9525 Burgess Road, TU-22-31

Please accept the following comments from El Paso County Public Health for the proposed Christmas Event:

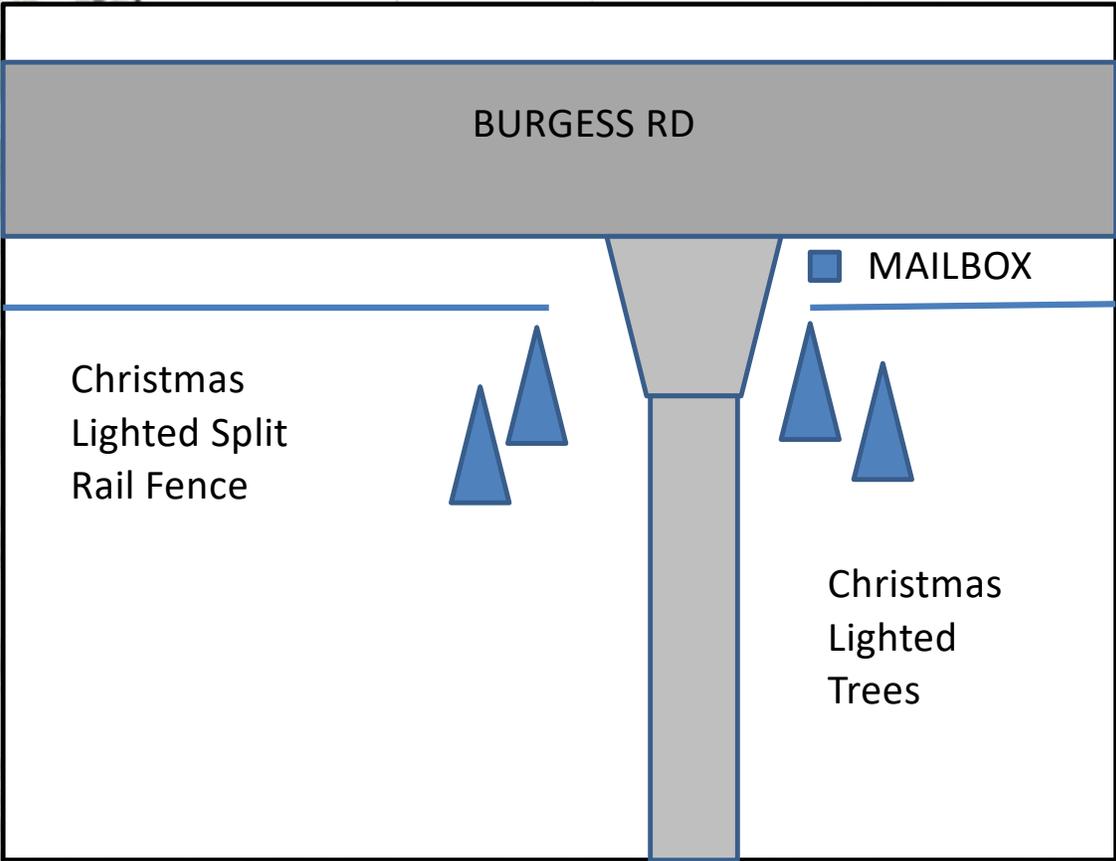
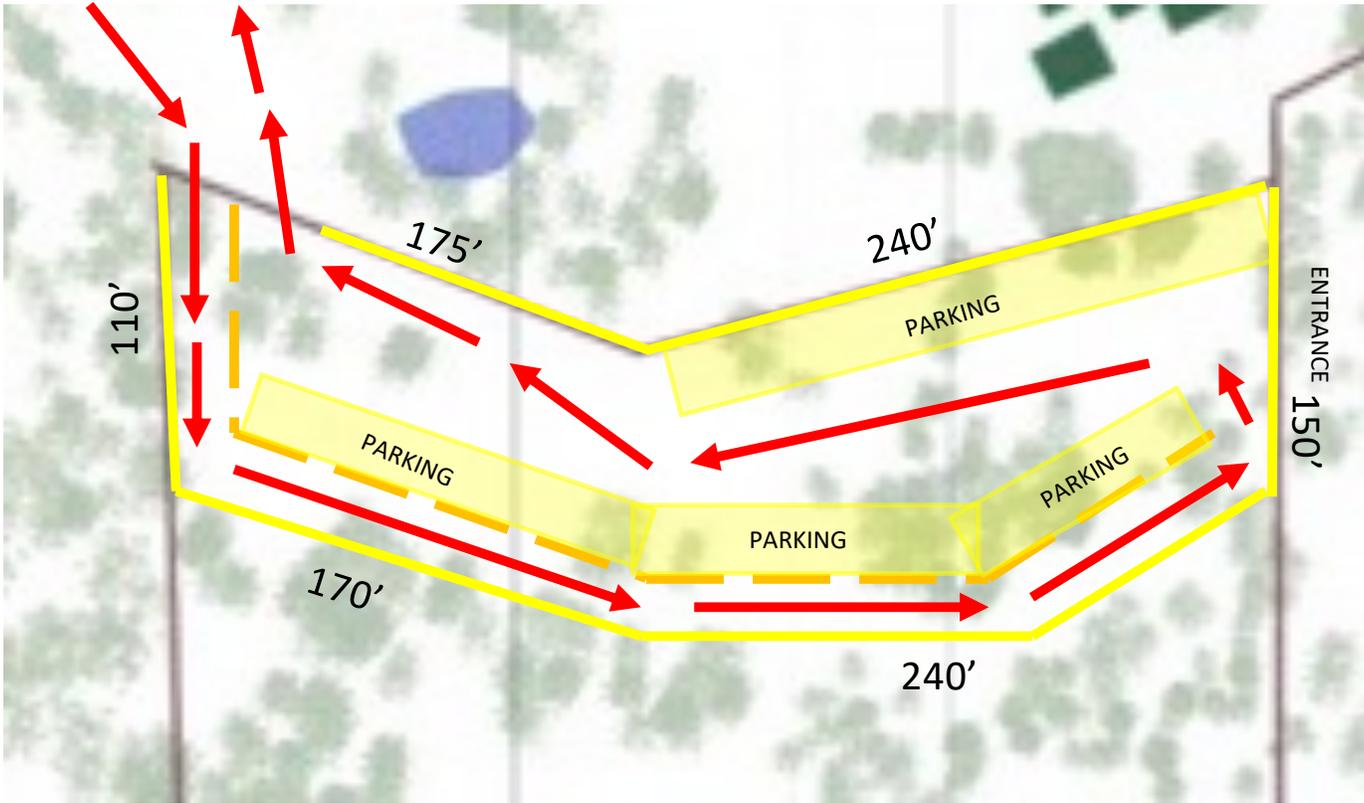
- The use of three (3) portable toilets with planned weekly servicing is approved. El Paso County Public Health recommends, but does not require, that portable handsinks be used in addition to hand sanitizers.
- The food concessions planned require input from El Paso County Public Health on licensing and food handling. Call 719-578-3199 and option #3 of Environmental Health and ask to speak to a representative of the Food Program for information.
- Locate your existing onsite wastewater treatment system (OWTS) servicing the residence, and especially the soil treatment area. Do not allow vehicle parking or driving over the soil treatment area to help prevent damage and premature failure of the OWTS.
